Comments on the Applicant's Response to Deadline 3 Submissions [Part 9 - Noise] by William David Moore

Introduction

00:00 on 25/04/2021 to 00:00 on 26/04/2021

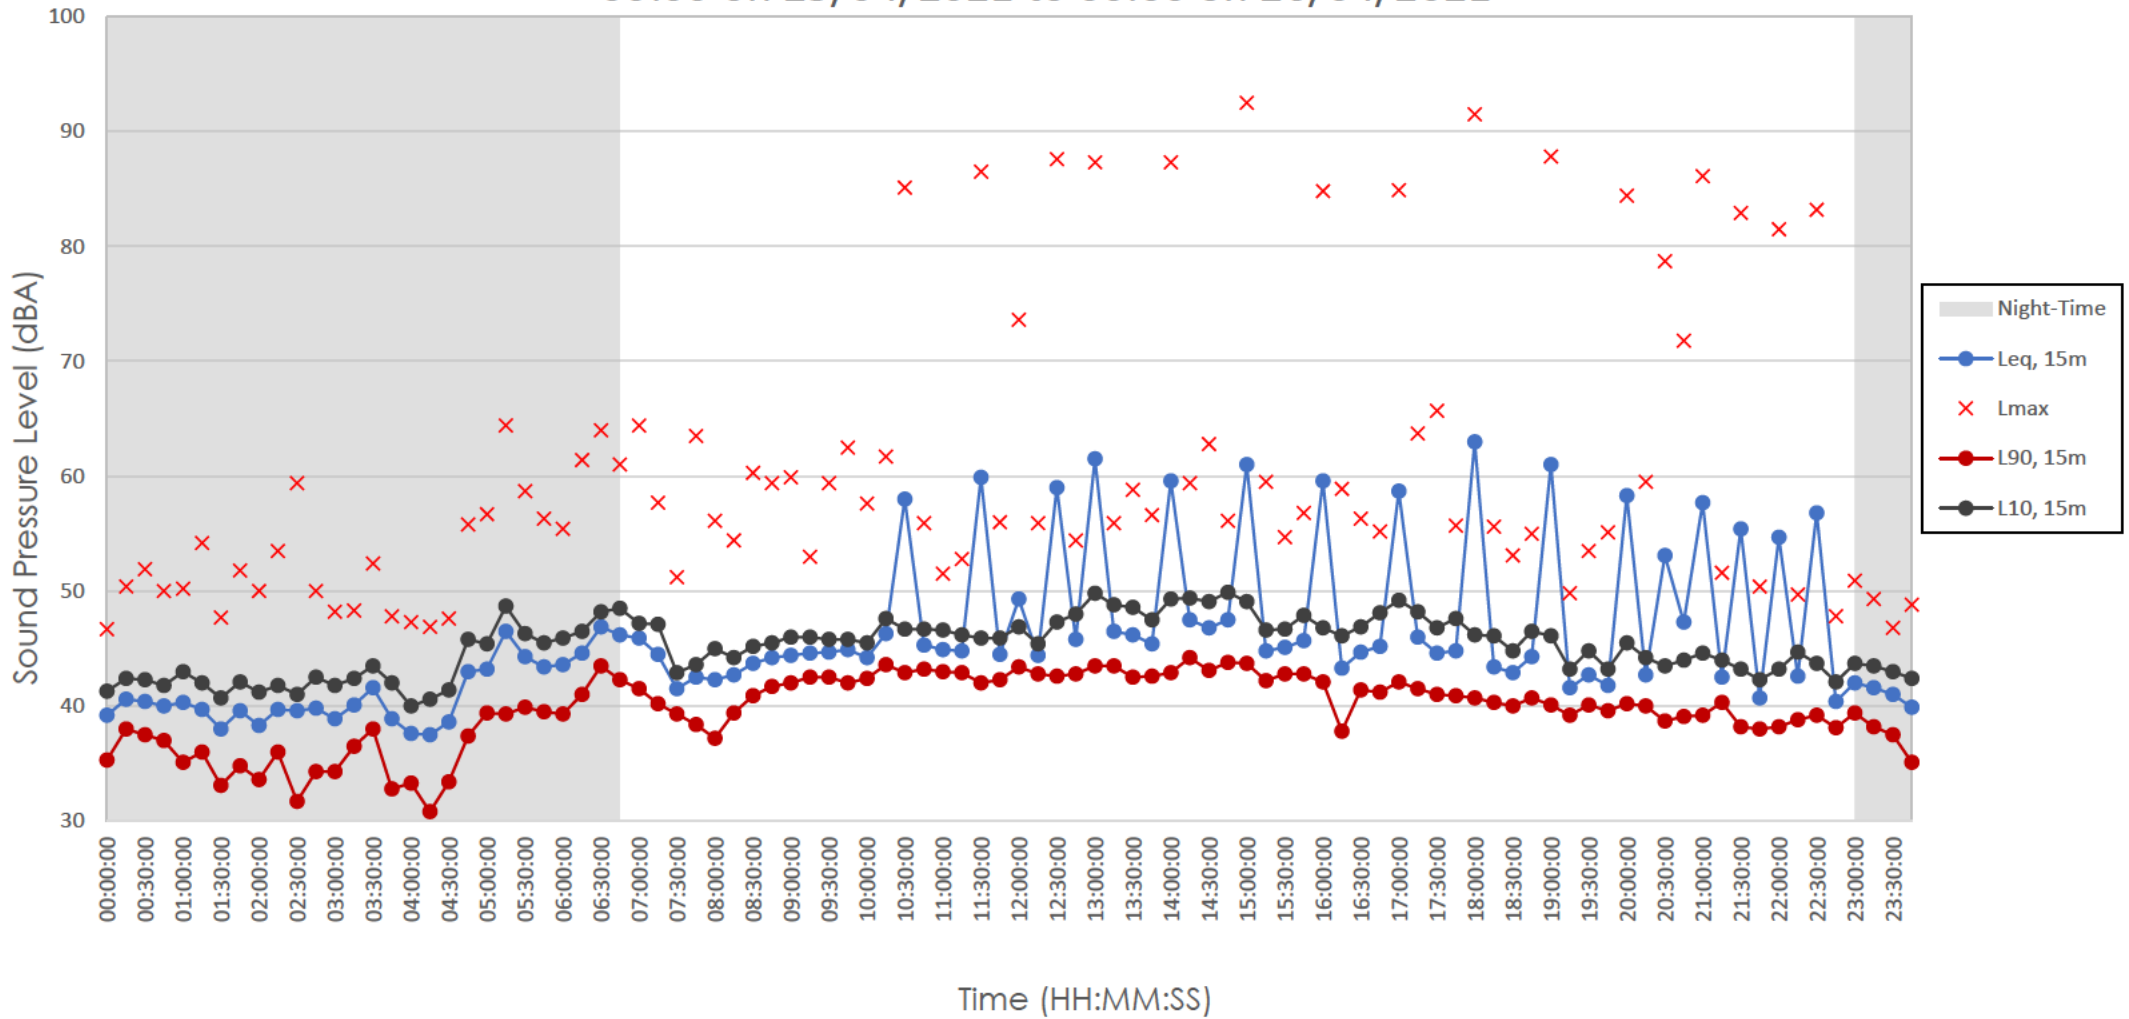
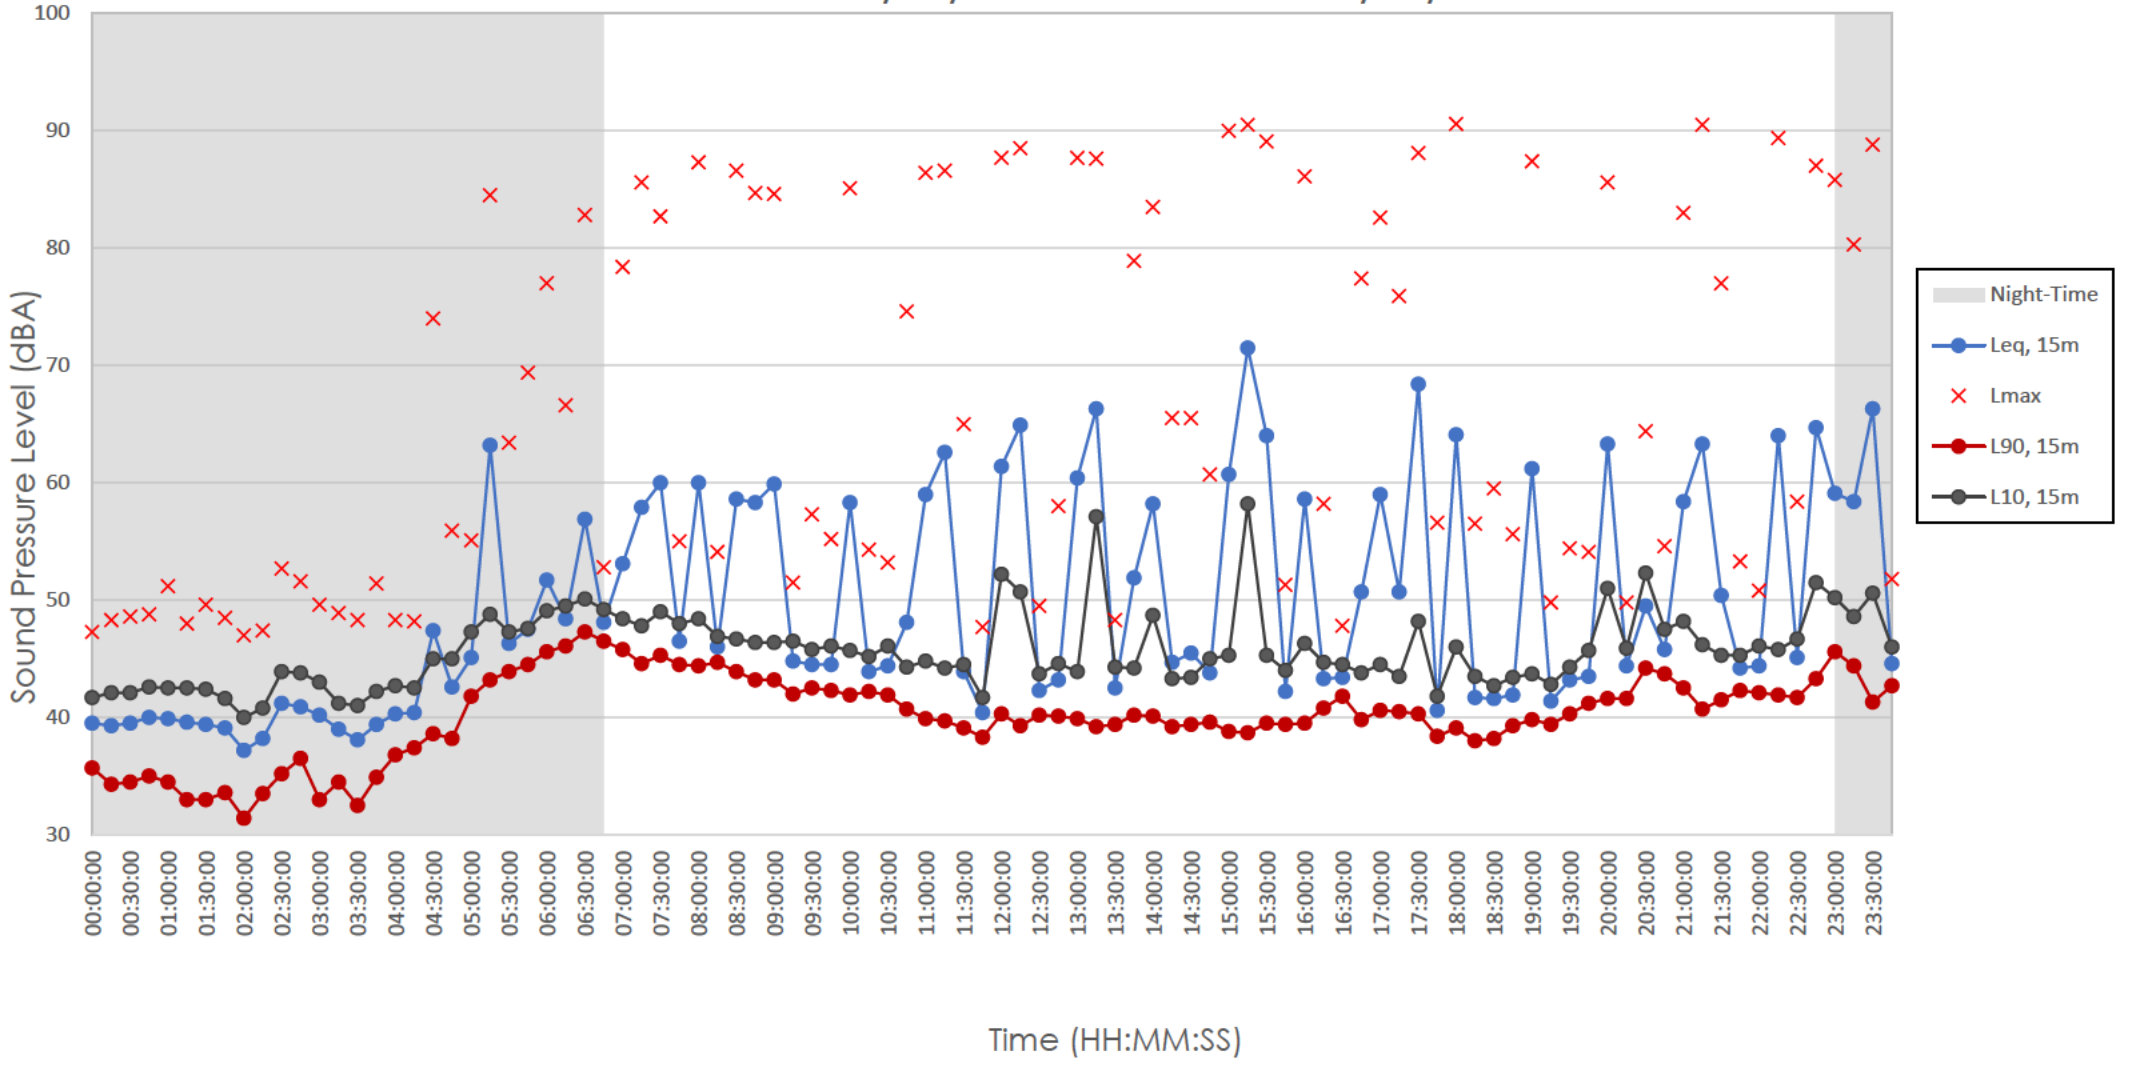
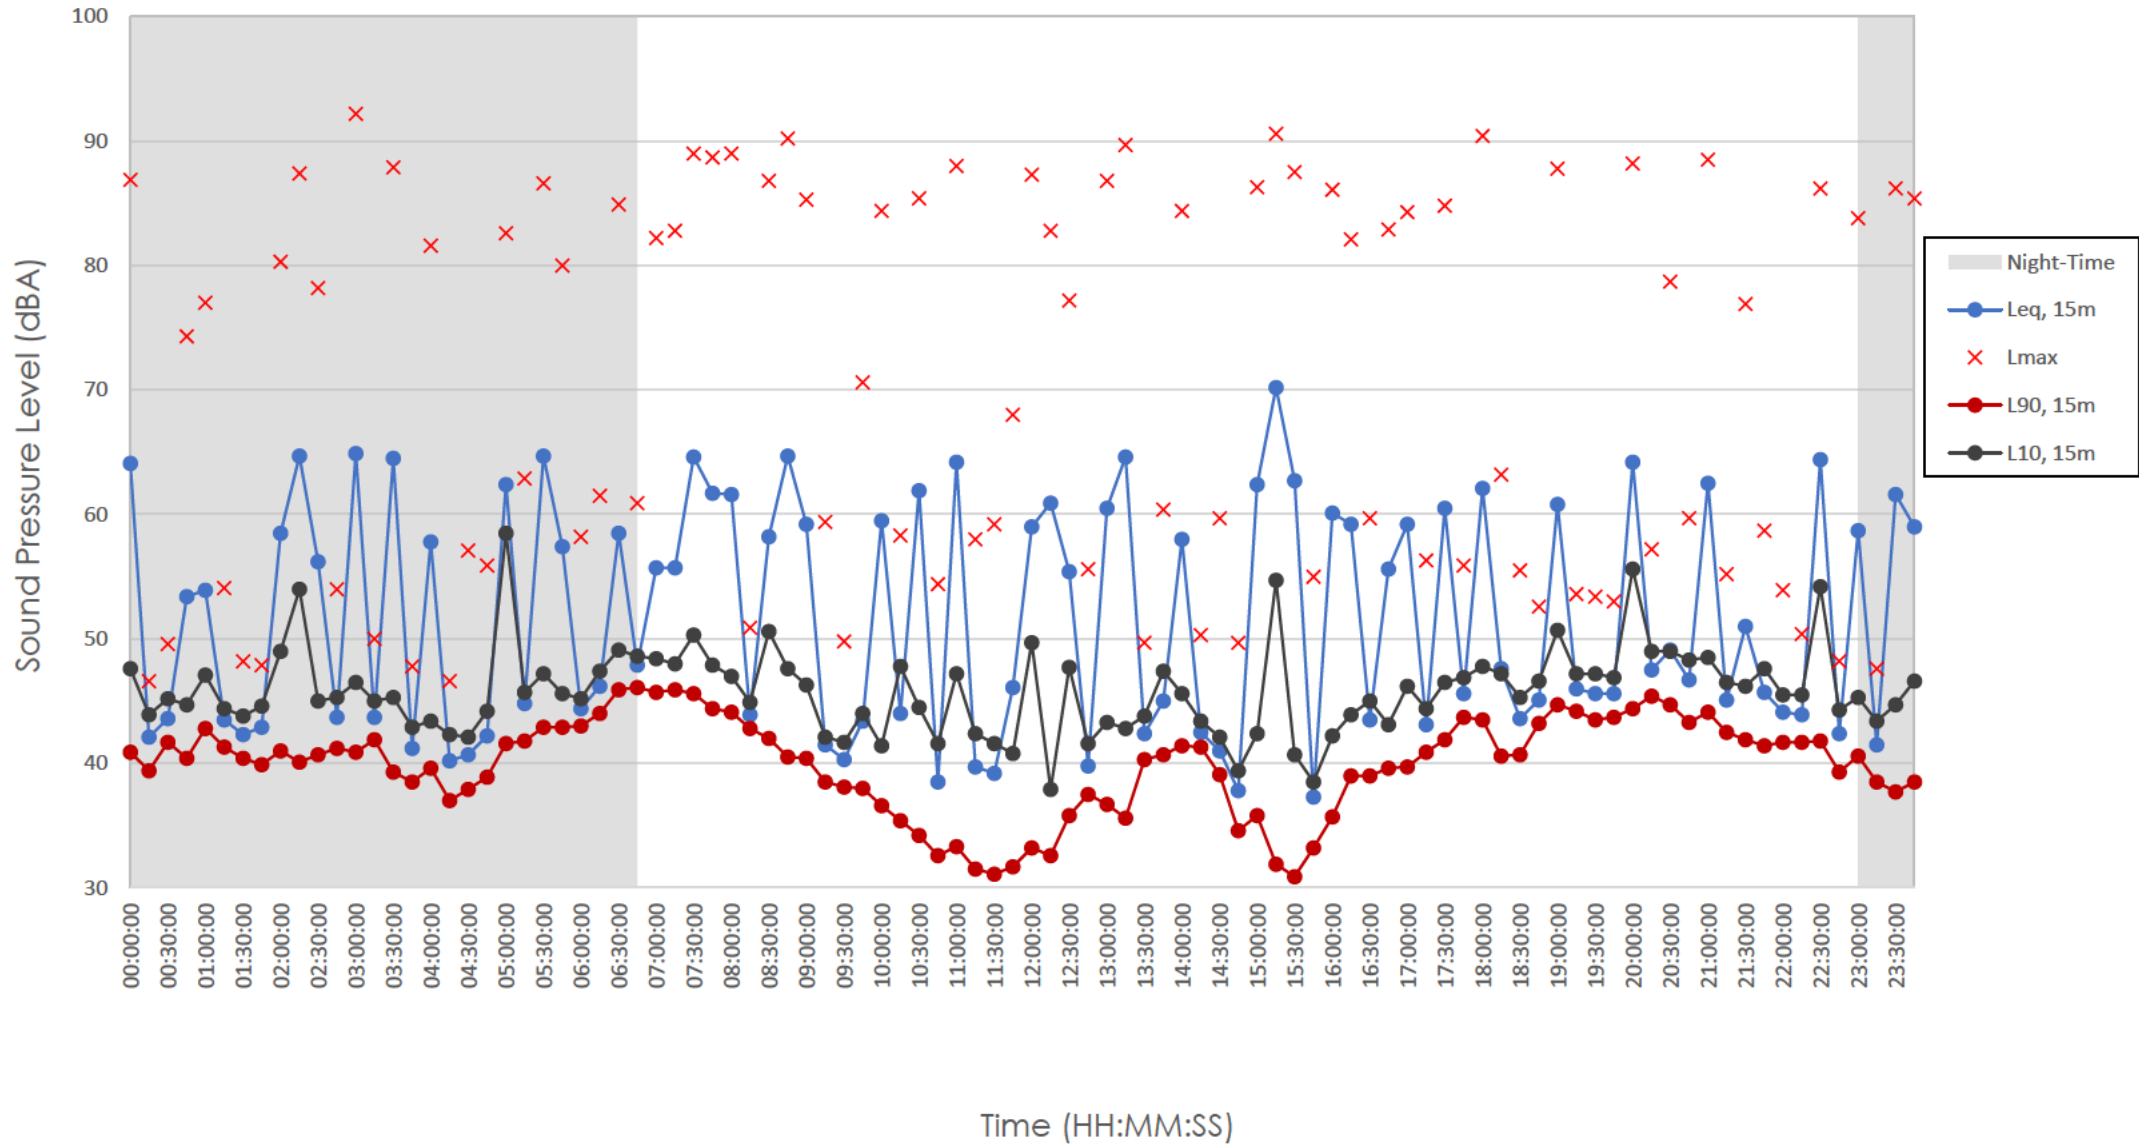
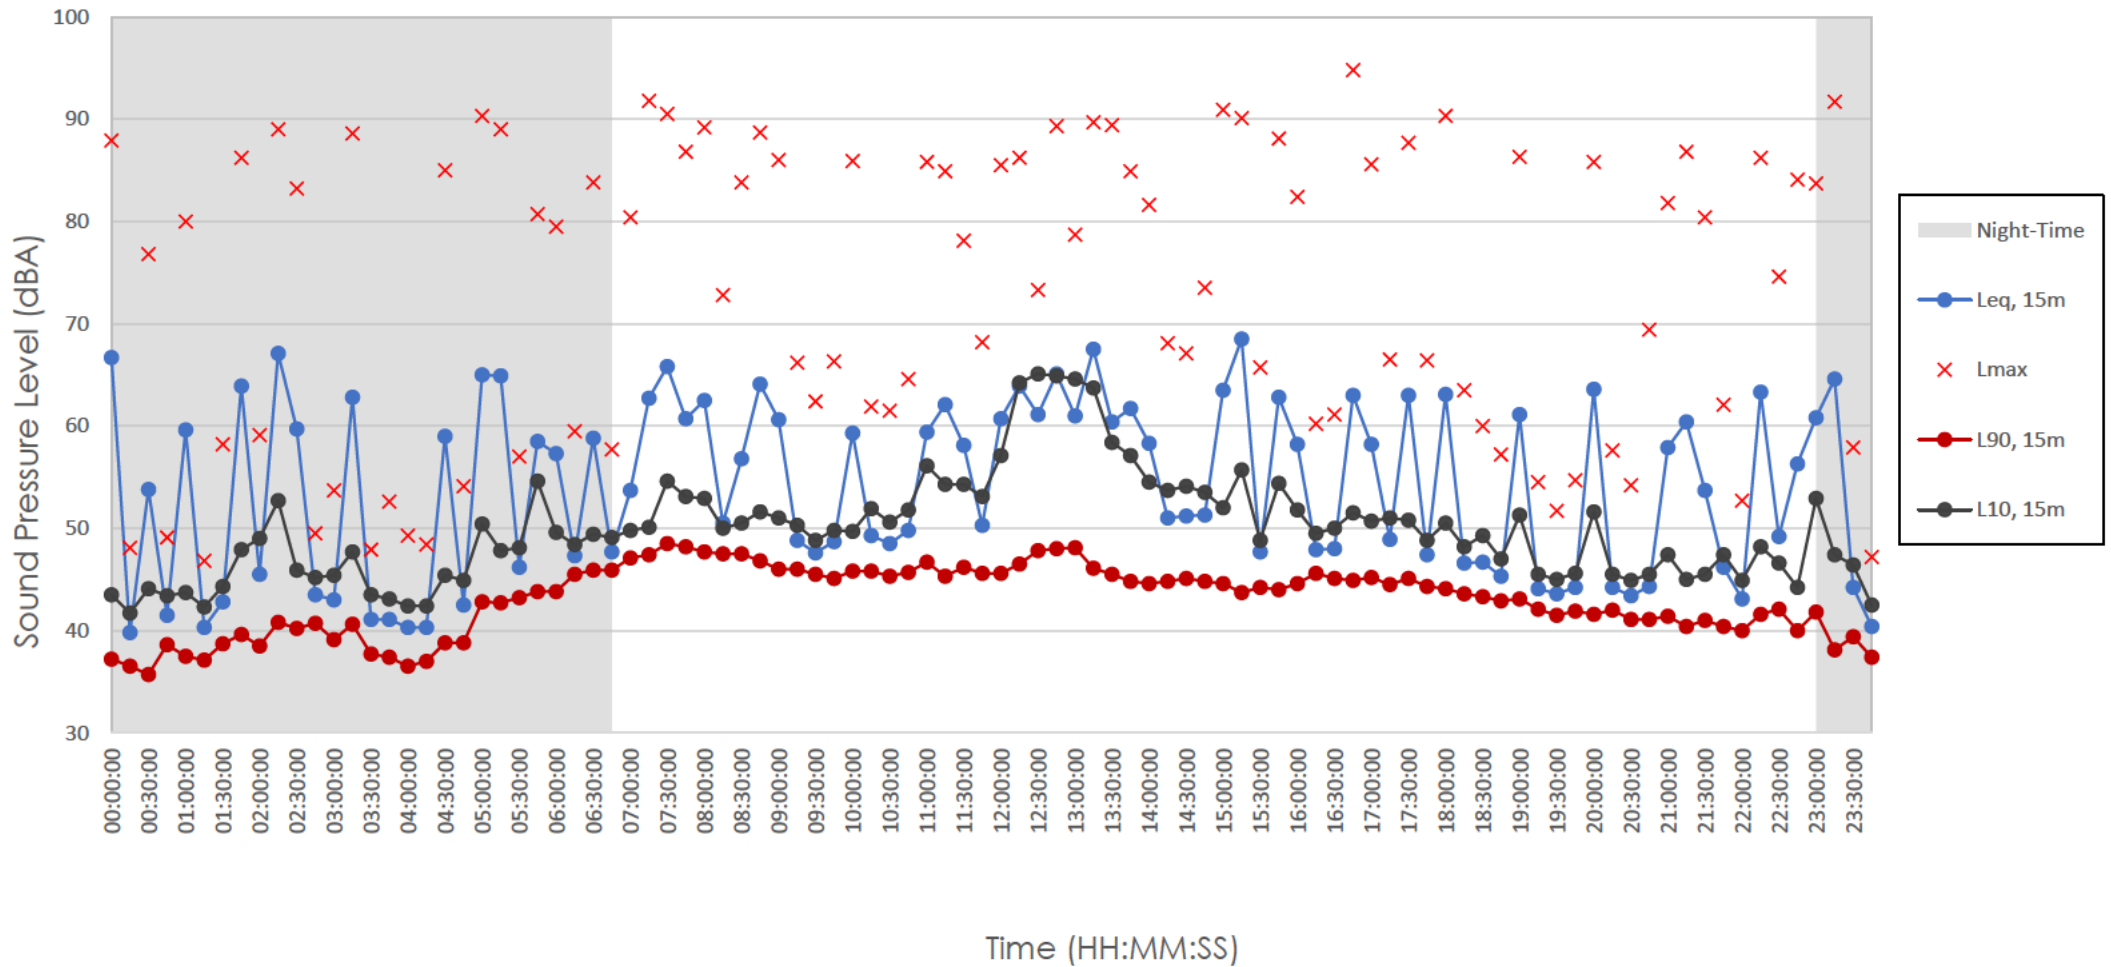
The update note doesn't address all eleven NSRs associated with NMP4. It only addresses the NSRs which it thinks are on Billington Road East.

The update note misstates the locations of NSRs 2, 3 & 4 and they should not have been included in Table 5.

The update note attempts to introduce rail noise contours to claim all the NSRs in Table 5 experience 50 dB of ambient rail noise, but all the NSRs in Table 5 are outside the contours.

The rail noise contours in the applicant's update note show sound levels far higher than those measured by NMP4 & NMP3.

The applicant needs to be returned to the sound levels measured by NMP4 and the applicant needs to apply attenuation corrections to the measured sound of train pass bys to generate ambient sound levels at NSRs 1-8 & 24-26 during weekday daytimes, weekday night-times, weekend daytimes and weekend night-times.

My written representation provided overwhelming evidence that NMP4's measured Saturday night-time noise levels should not have been expunged and that Sunday night-time train pass bys are structurally higher. The evidence showed four consecutive Saturday night-times having a **maximum** of one passenger train which may or may not pass by in the first few minutes of the night.

If the applicant continues to deny reality and continues to refuse to reinstate the Saturday night-time noise levels measured by NMP4 then I will submit yet more evidence. The applicant's purported "understanding" of weekend night-time train pass bys is uninformed.

The applicant is retreating to strategic contours. We have levels measured on the ground at the site: The measurements of NMP3 & NMP4. Both of those NMPs show sound levels far lower than those depicted by the strategic contours which the applicant is attempting to rely on.
